PROJECT TITLE: GORMAN ZONE MAP: J13
DRB#: --- EPC#: --- WORK ORDER#: ---

**RE: Gorman Warehouse Addition
1330 12th Street NW
Request Permanent C.O. – Accepted
Engineers Stamp Date 2/11/15 (J13D100)
Certification Dated (1-15-16)**

Re: Gorman Industries, Warehouse Addition
1330 12th St., NW
Request for Certificate of Occupancy- Transportation Development
Engineer's/Architect's Stamp dated 11-26-14 (J13-D100)
Certification dated 1-13-16

Re: Gorman Industries, Warehouse Addition
1330 12th St., NW
Request for Certificate of Occupancy- Transportation Development
Engineer's/Architect's Stamp dated ~~12-1-14~~ (J13-D100)
Certification dated 1-13-16 *11-26-14*

Detailed used for
TCL at
1330 12st St, NW
02-29-16 bja

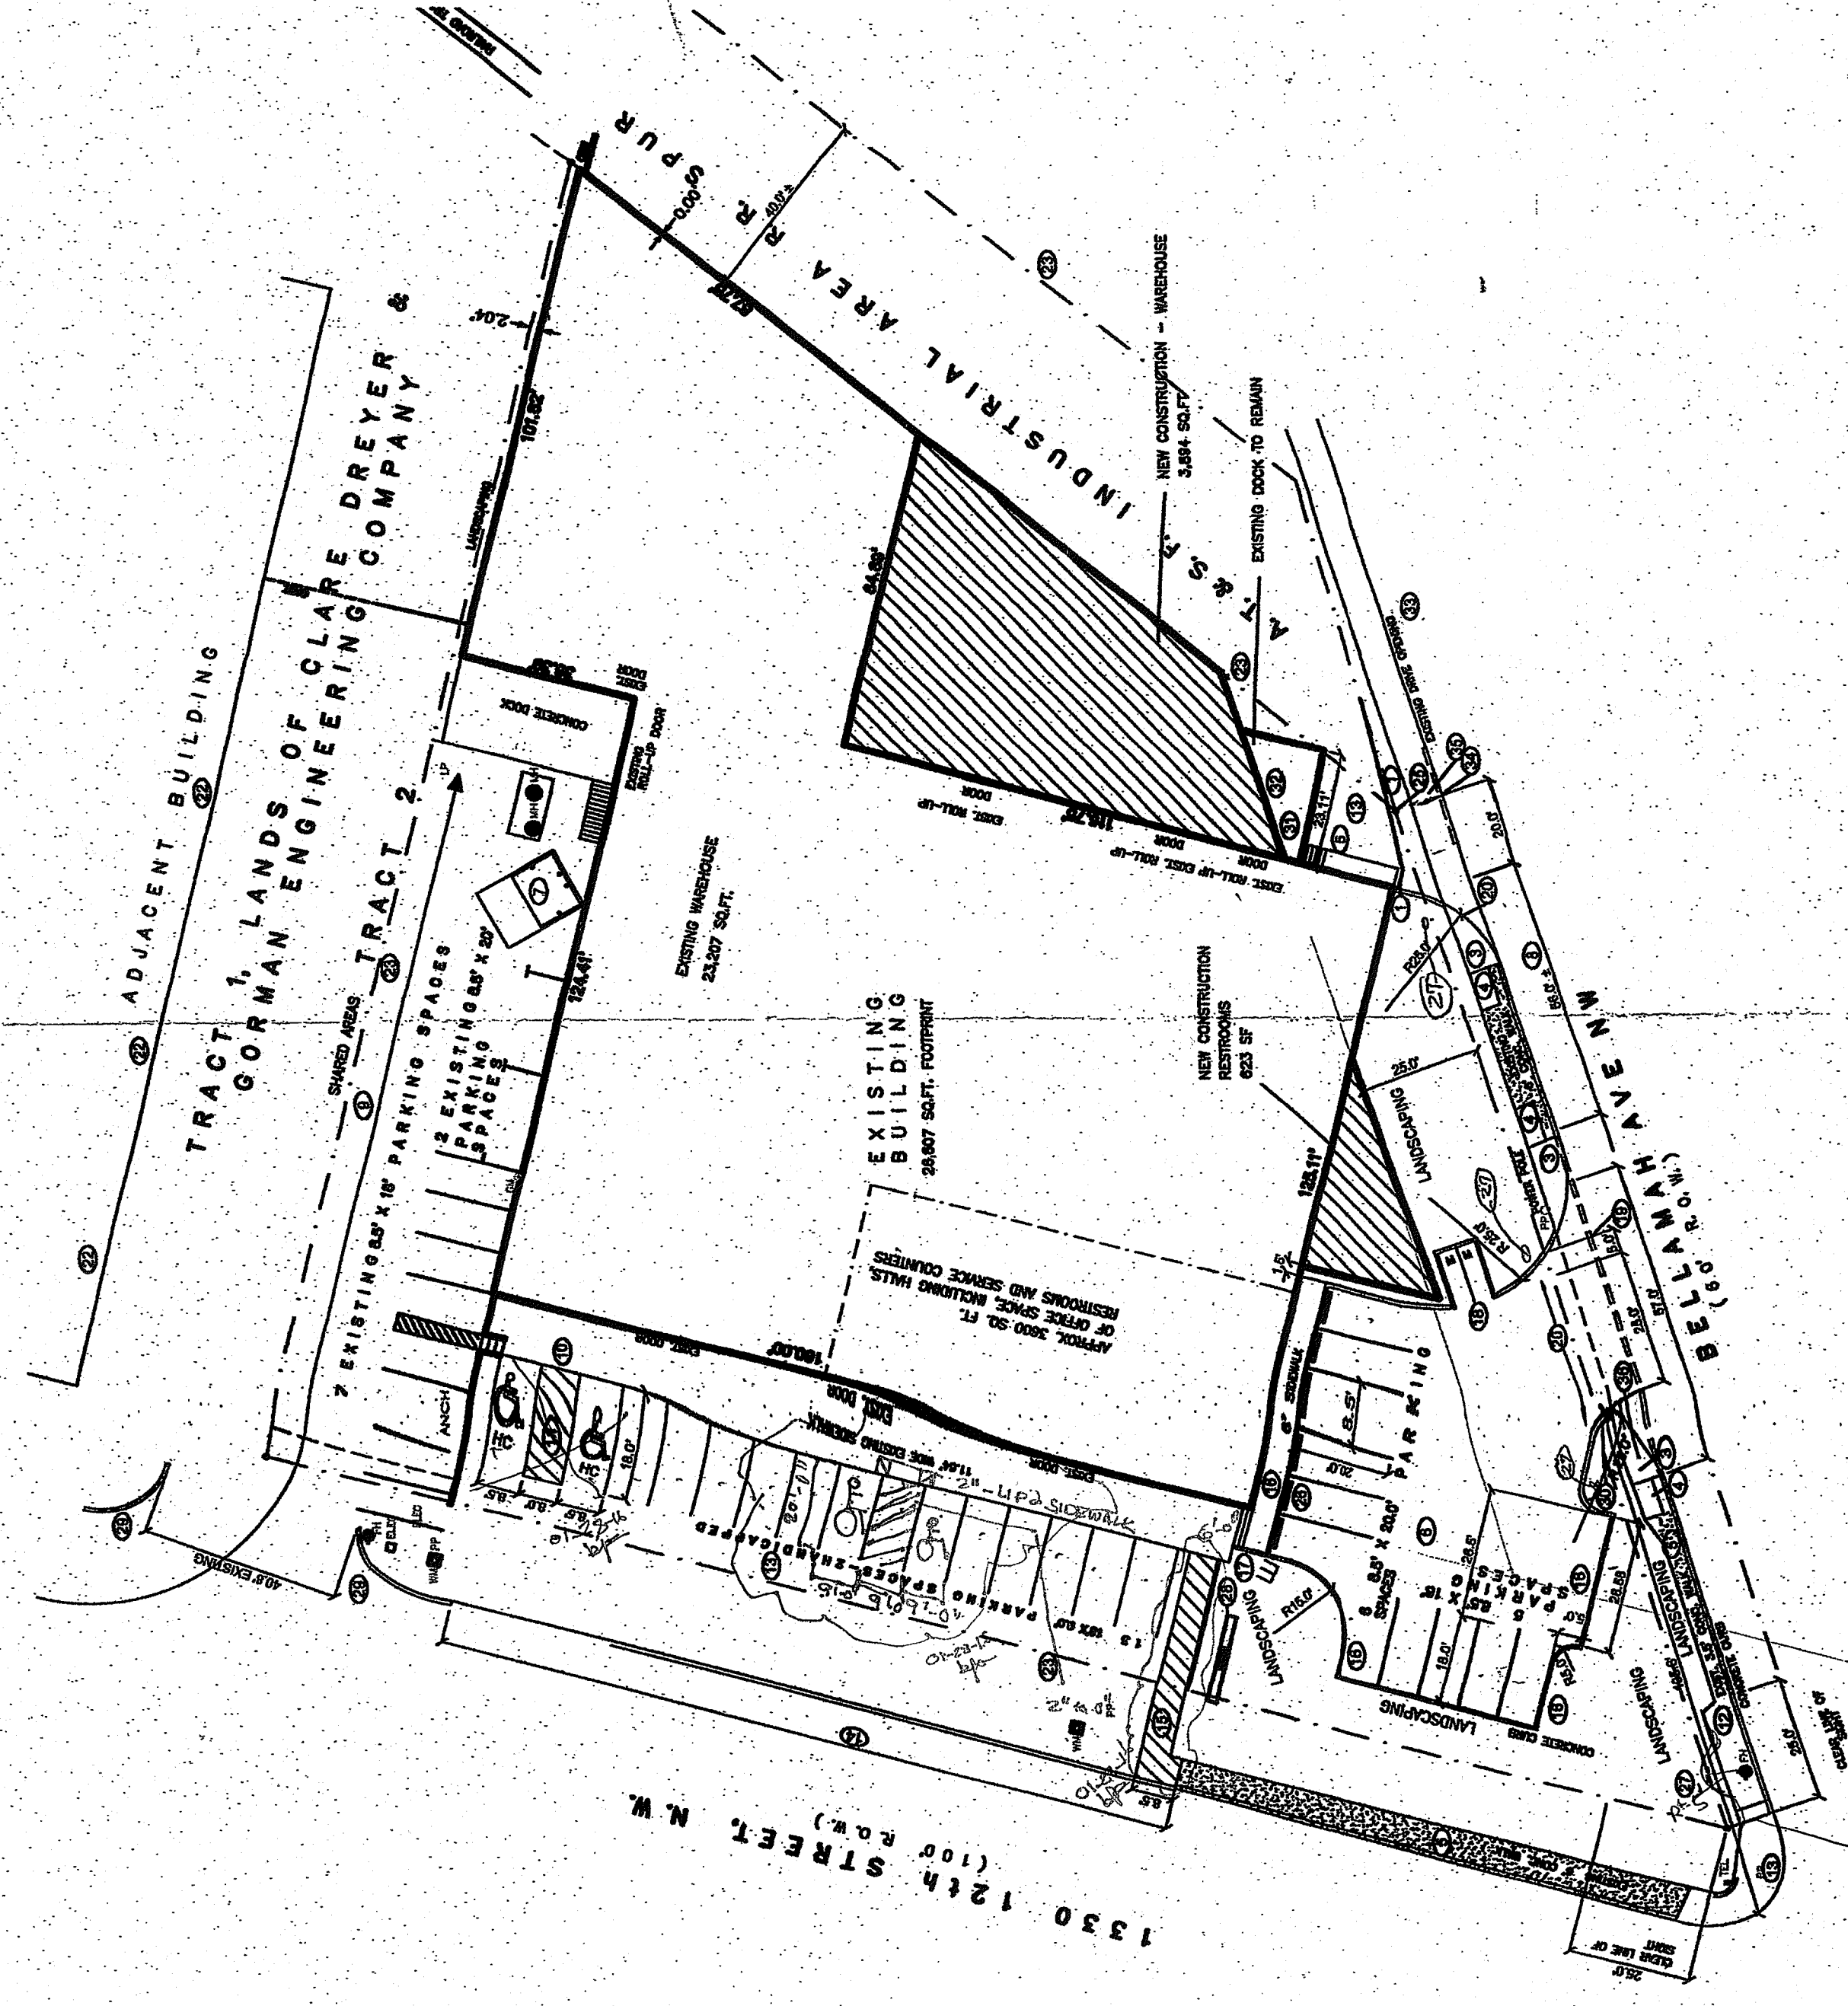
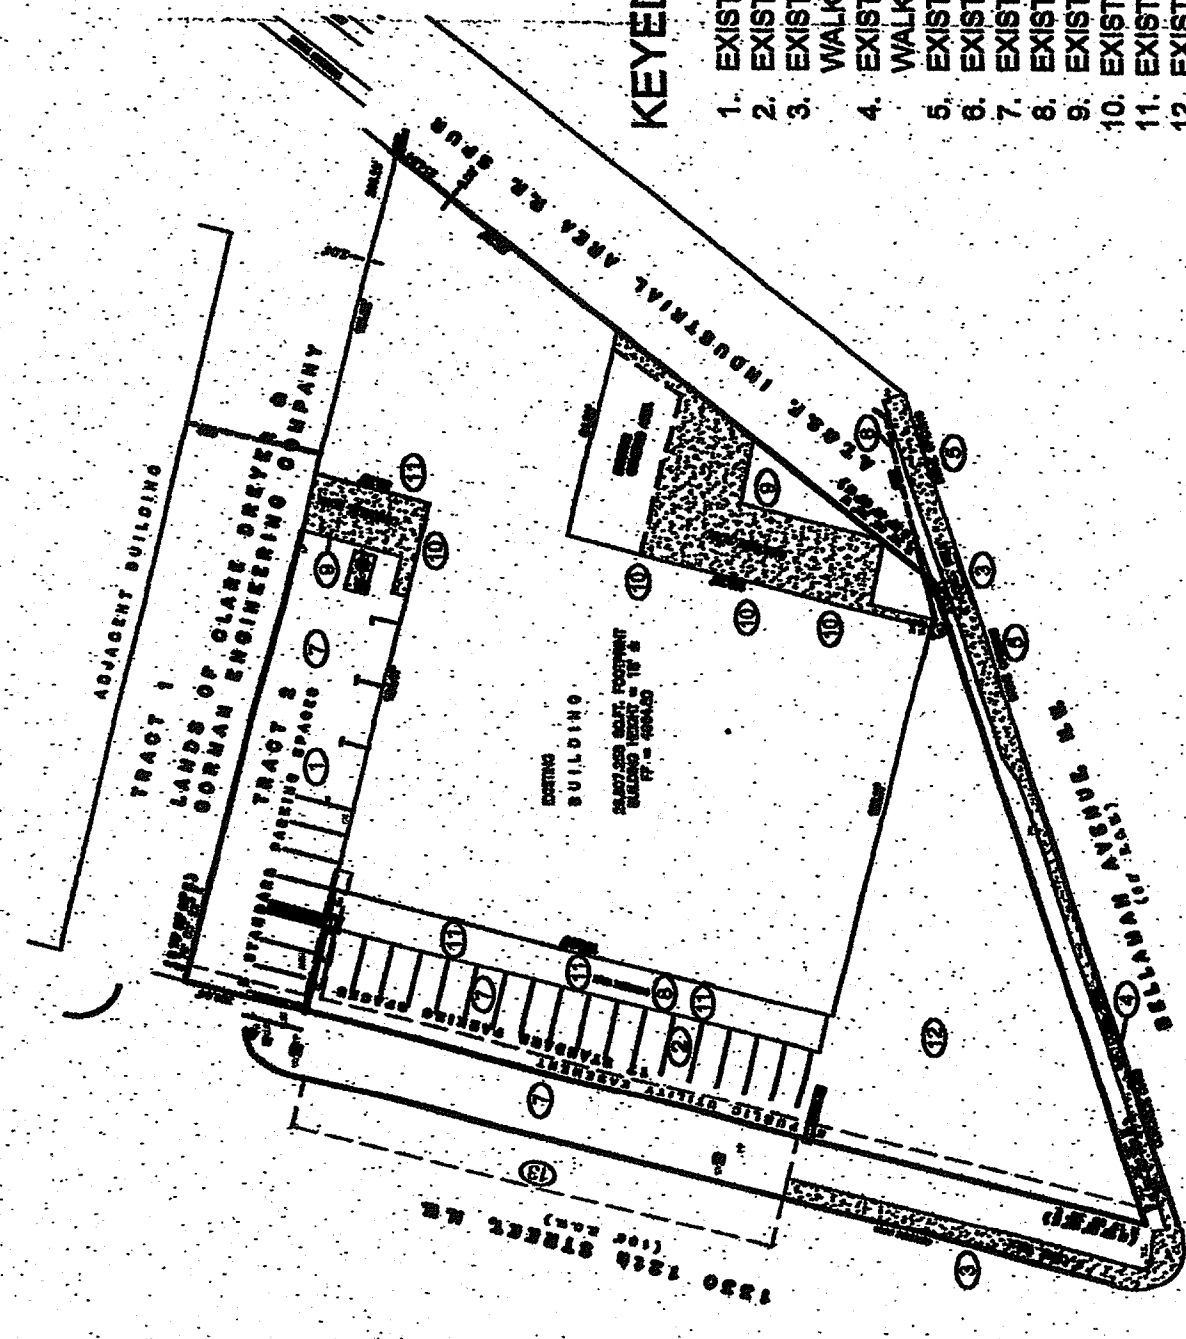
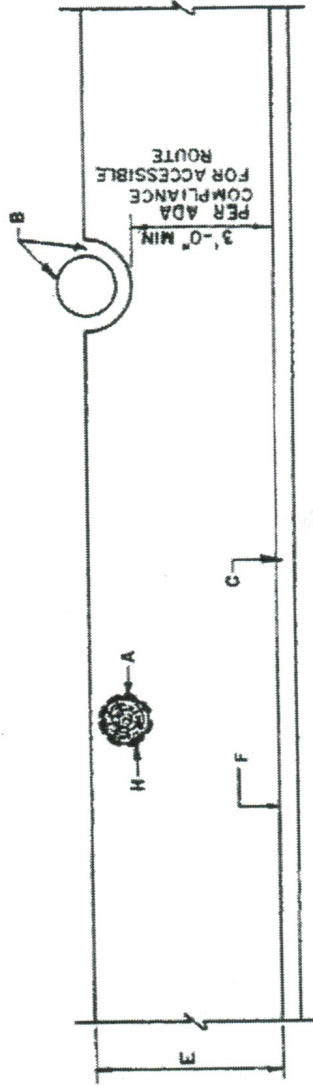
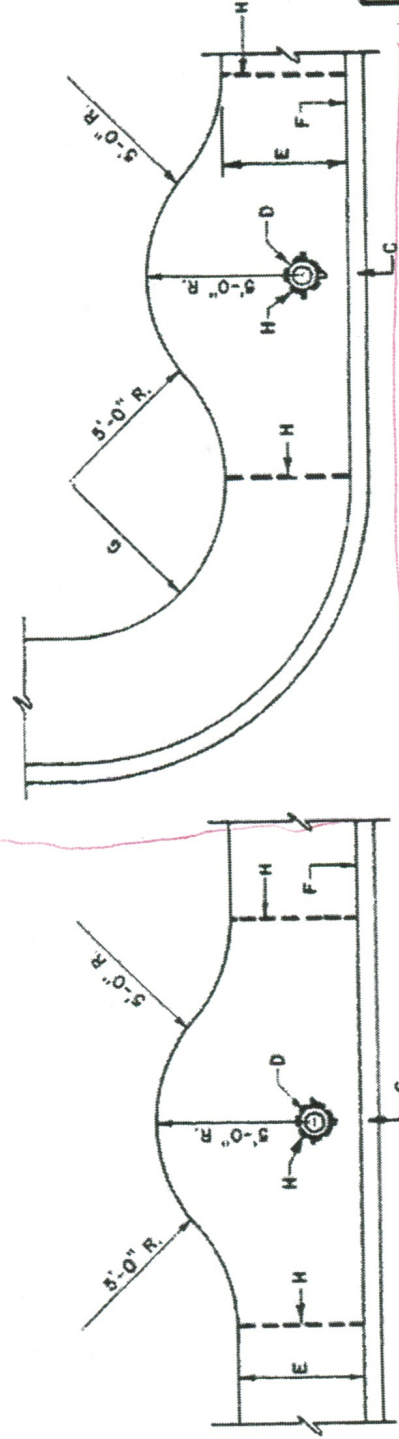
- ADA sidewalk at the south west corner of the project site at the fire hydrant must be reconstructed in accordance to COA standard drawing #2431.
- An easement must be created for the encroachment of a public right-of-way onto the projects property at the fire hydrant location.
